Title: **STAGE 1 ROAD SAFETY AUDIT**

Holybanks Swords

Client: **Cairn Homes/Waterman Moylan**

Report reference: **0934R01**

CLIENT	CAIRN HOMES PROPERTIES LTD.		
ARCHITECT	MCORM ARCHITECTS		
PROJECT	SHD AT HOLYBANKS, SWORDS		
TITLE	PROPOSED ROADS LAYOUT & LEVELS (SHEET 1 OF 2)		
DRAWN	DESIGNED	APPROVED	DATE
PW	LRG	EC	MARCH 2022
SCALE	JOB NO.	DRG. NO.	REVISION
1:500 @ A1	17-088	P002	-

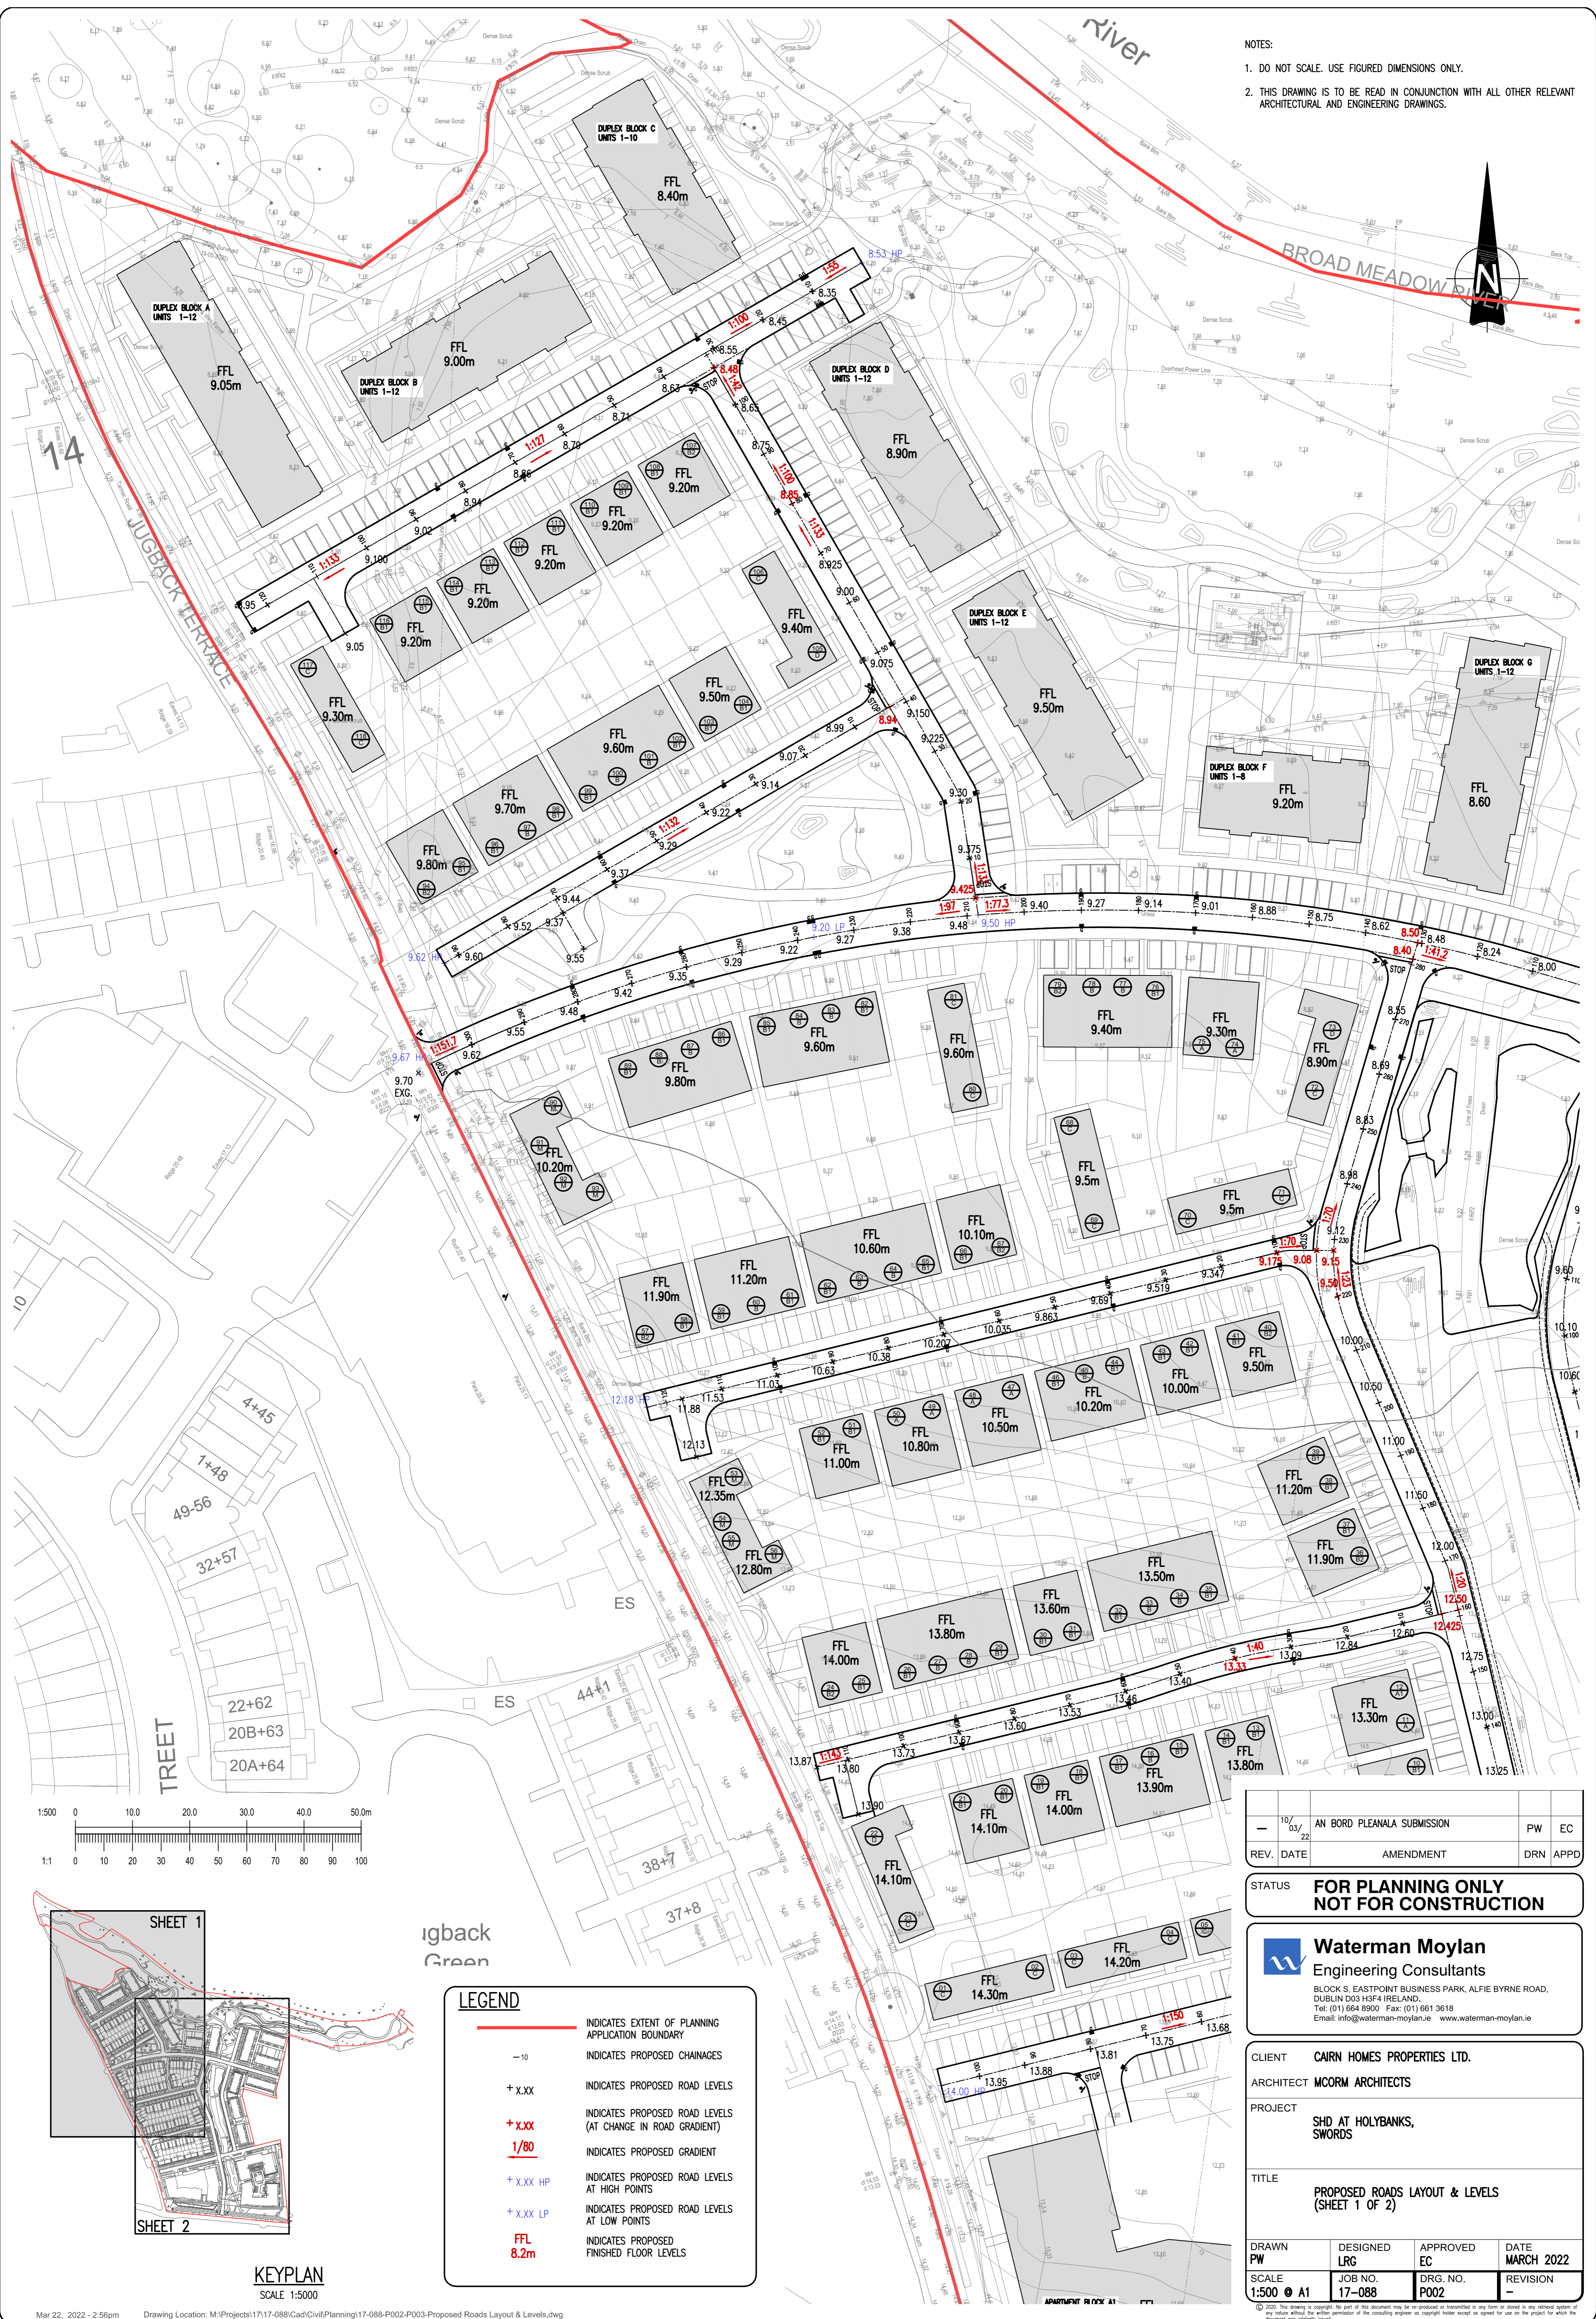
It is proposed to provide a crossroads on Jugback Terrace with a yield control for vehicles exiting the proposed development. There is a risk that given the relatively low number of vehicles that will be travelling from the single dwelling at the end of Jugback Terrace that drivers exiting the proposed development may not expect conflicting traffic and may travel across Jugback terrace without yielding or stopping resulting in side-impact collisions.

It is recommended that the development access be staggered from the access to Applewood Lane.

Jugback Terrace is a narrow single carriageway road with a pinch-point in the cross section and a crest in the vertical alignment between the proposed vehicular access and the junction with Glen Ellan Road. The increased traffic volumes could lead to an increased likelihood of head-on (vertical) or side-swipe (pinch-point) collisions along the carriageway.

It is recommended that the cross section and vertical alignment be checked for compliance with the design speed and with the guidance provided in DMURS for stopping sight distance and for carriageway widths.

The corner radii at the internal junctions appear to be large which leads to higher turning speeds, longer crossings and higher severity injuries if vulnerable road users are struck.

It is recommended that corner radii are provided in accordance with the guidance provided in DMURS.

The internal junctions are proposed to generally have Yield control. This leads to higher turning speeds and higher severity injuries if vulnerable road users are struck.

It is recommended that Stop control is provided in lieu of Yield control.

The internal footpaths within the development have ramp type markings and transverse markings. It is unclear what the transverse markings represent. There is a risk that if the gradients are excessive on the footpaths that certain areas will not be accessible to the mobility impaired.

It is recommended that footpath gradients within the development comply with the limits set out in Part M of the Building Regulations.

Some internal footpaths do not align at uncontrolled crossing points of the road network. This could lead to difficulties for crossing of the carriageway for blind or partially sighted pedestrians.

It is recommended that footpaths at the opposite side of uncontrolled crossings align perpendicular to the direction of vehicular traffic travel.

There is a risk of surface water ponding at the dropped kerbs associated with uncontrolled pedestrian crossings without adequate drainage upstream. There is a risk of trips and falls if gully gratings are provided in the line of an uncontrolled crossing.

It is recommended that surface water gullies are provided immediately upstream of all uncontrolled pedestrian crossing points .

The proposed disabled parking space outside Block L is orientated at 90 degrees to the adjacent parking spaces. It is unclear how a driver could enter/exit this space if the adjacent spaces are occupied. This could result in a lack of facilities for disabled drivers, resulting in parking in areas that may be hazardous for other road users such as footpaths.

It is recommended that the parking layout be revised.

The proposed access road from Jugback Terrace has a constant large horizontal radius, is 300m long and is the priority route along its length. This may lead to high speeds and result in high severity collisions if vulnerable road users are struck.

It is recommended that a more sinusoidal alignment is provided or that alternative traffic calming measures be provided.

3.1	Yes	No	Due to the very low traffic likely to be on Jugback Terrace it is proposed to change the priority. A stop line will be installed on both sides of Jugback Terrace. See attached amended drawing no. 17-088/ P002 Rev A	Yes

3.2	Yes	No	Jugback Terrace is outside of the redline boundary. There is no vehicular access/parking to the proposed residential units on Jugback Terrace. There is existing parking on Jugback Terrace. Jugback Terrace is intended to be primarily used as a pedestrian/cycle route. The existing pinch point serves to reduce traffic speeds. Additional signage and road markings will be installed to highlight the pedestrian and cycle activity.	Yes

3.11	No	No	Corner Radii are generally 4.5m to accommodate occasional large vehicles (refuse trucks). See drawing 17-088/P004 and P005 which complies with DMURS for occasional larger vehicles as per Figure 4.43 in DMURS	Yes

3.12	Yes	Yes	Stop signs will be provided at internal junctions.	Yes

3.13	Yes	Yes	Footpath gradients will be reviewed at detailed design stage in order to comply with Building Regulation guidelines for mobility access. The traverse lines are a landscape architect paving feature which have been removed from our engineering drawings.	
3.14	Yes	Yes	Uncontrolled pedestrians' crossings have been amended to ensure perpendicular crossings.	
3.15	Yes	Yes	Gullies have been relocated immediately upstream of all uncontrolled pedestrian crossing points and road levels adjusted to have the low at the new gully locations.	
3.16	Yes	Yes	Disabled space has been relocated	
3.17	Yes	Yes	Additional traffic calming measures will be provided at detailed design stage, which may include build outs along the open space to reduce traffic speeds and or raised tables.	
3.18	Yes	Yes	Road has been extended to provide safe access to on-curtilage parking at unit 94.

DRAWN	DESIGNED	APPROVED	DATE
PW	LRG	EC	MARCH 2022
SCALE	JOB NO.	DRG. NO.	REVISION
1:500 @ A1	17-088	P003	-

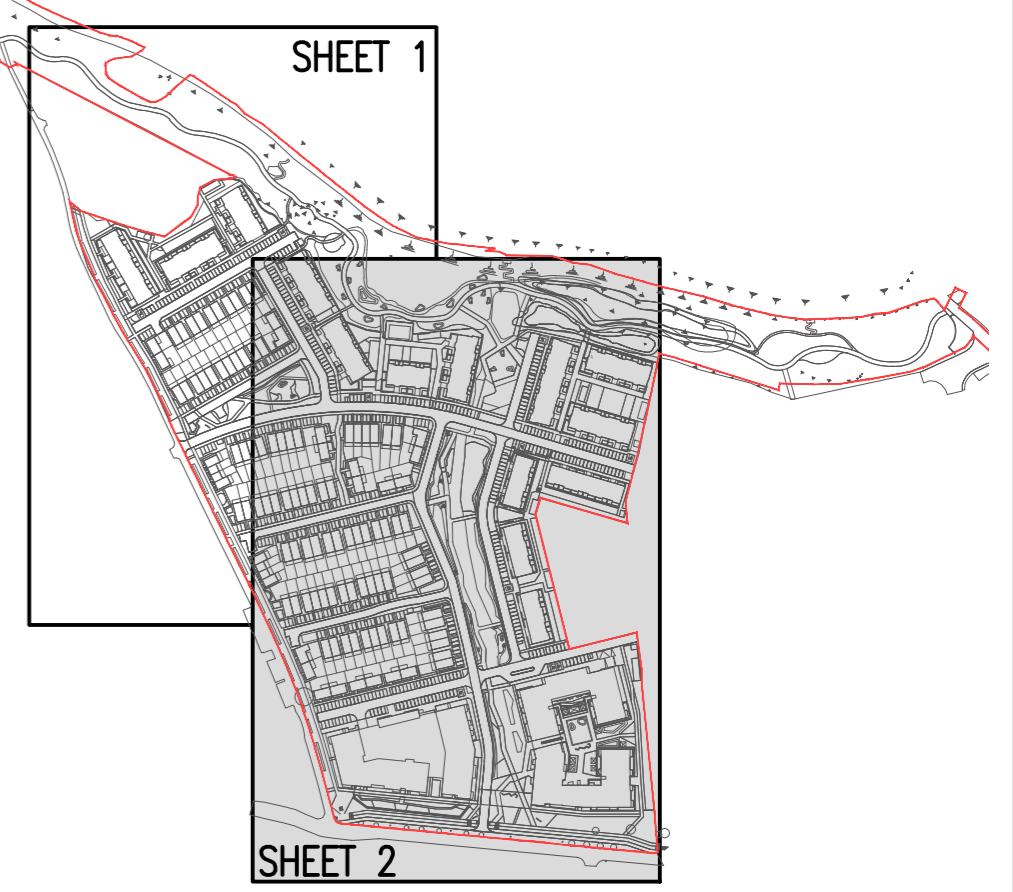
There is no access for the on-curtilage car parking spaces for unit 94. This could lead to drivers travelling/reversing on the footpath or green areas where they could collide with children

It is recommended that road access be provided to unit 94.

DRAWN	DESIGNED	APPROVED	DATE
G.Byrne	LRG	EC	MARCH 2022
SCALE	JOB NO.	DRG. NO.	REVISION
AS SHOWN @A1	17-088	P011	-

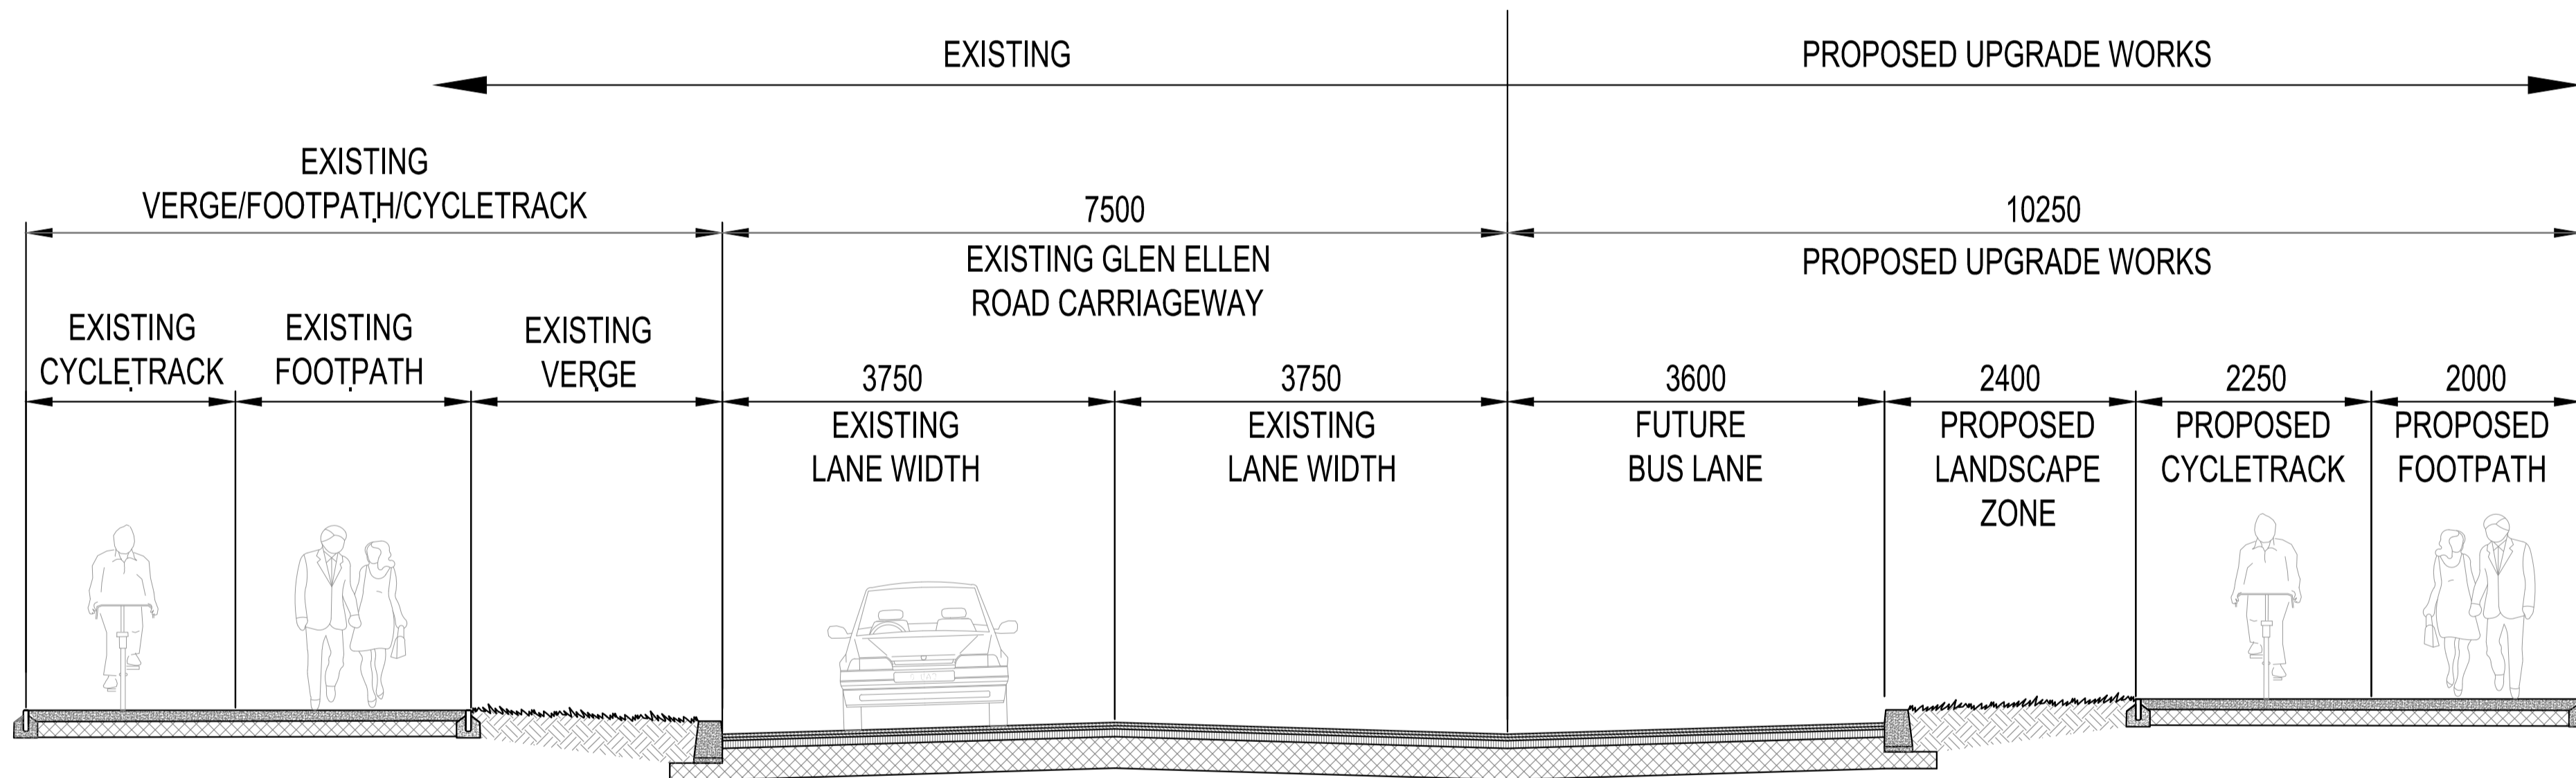
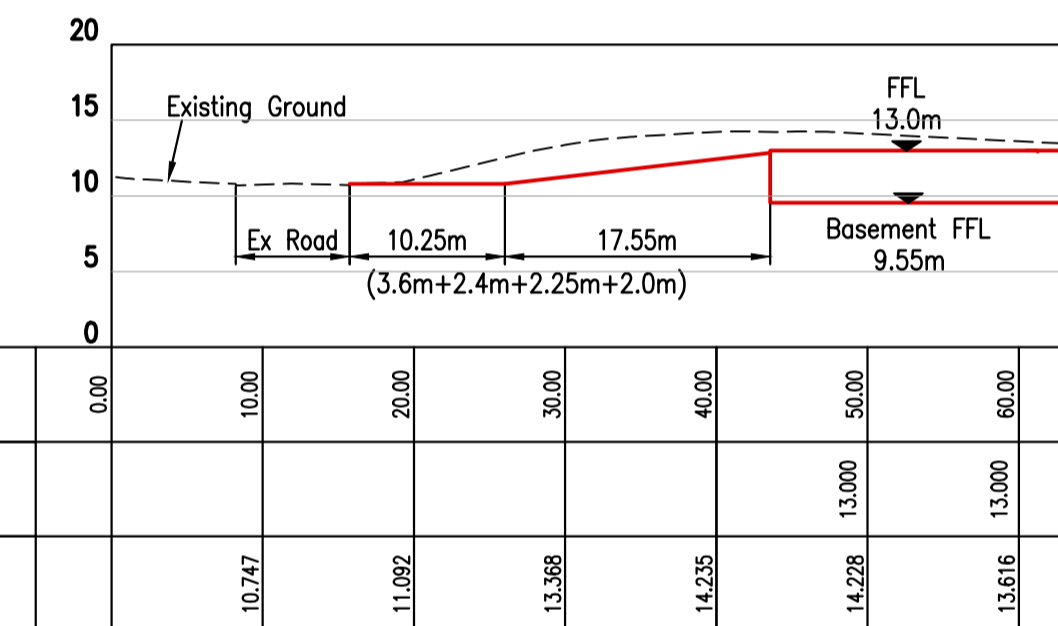
It is proposed to terminate the cycle track at the access to private lands at the eastern boundary of the development. This will lead to a short discontinuity in cycle facilities between this point and the approach to the Balheary Road Junction where the cycle track recommences. The merging of cyclists with general traffic will lead to an increased likelihood of a collision.

It is recommended the cycle track be made continuous along the verge of Glen Ellan Road.

There is a pedestrian desire line across Glen Ellan Road for those wishing to travel via Jugback Lane to Swords town centre or to Swords Community College. The demand will increase when the new development is constructed. It is unlikely that pedestrians are going to cross at the existing signalised crossing to the West of Jugback Lane.

It is recommended that a controlled signalised crossing be provided on Glen Ellan Road that caters for the desire line along Jugback Lane.

3.3	No	No	Junction priority is proposed to be changed as per response to Problem 3.1 above.	Yes
3.4	Yes	Yes	Continuity of cycle track along Glen Ellen Road is outside the applicants control. The matter will be referred to Fingal County Council. We would note that the lands fronting this section of Glen Ellen Road are zoned for development and consequently are likely to be developed in the future. Continuity of the cycle lane can be provided at this time.	Yes

3.5	Yes	No	Due to locations of existing bus stops it is not possible to locate the pedestrian crossing at the desire line. The existing crossing is only 60m from the junction.	Yes
